Change of use of The Little Yard to independent dwelling & the stationing of up to 4 No. Shepherd Huts to be used as tourist accommodation. This application affects a Public Right of Way, may affect the setting of a listed building & affects the character & appearance of the Church Lane, Barnham Conservation Area.
Barnham Court Farm Church Lane Barnham

Thank you for your internet representation made on 8th October 2019 which has been recorded as '**an objection**' with the comments as follows:

Site 2 Farmyard / Canal

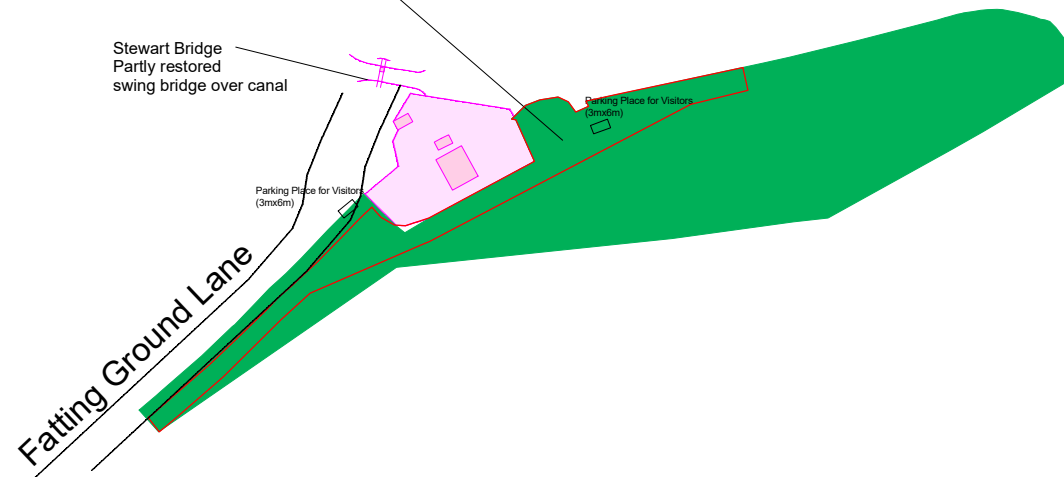
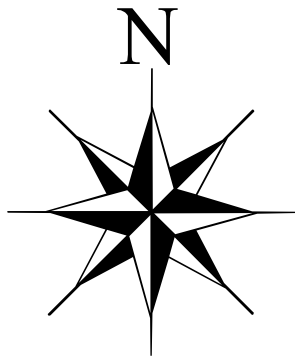
The panel require more information to make a decision. Lack of information about the design, appearance and size of the Shepherd's Huts and parking arrangements. Also, if there will be any impact on the canal.
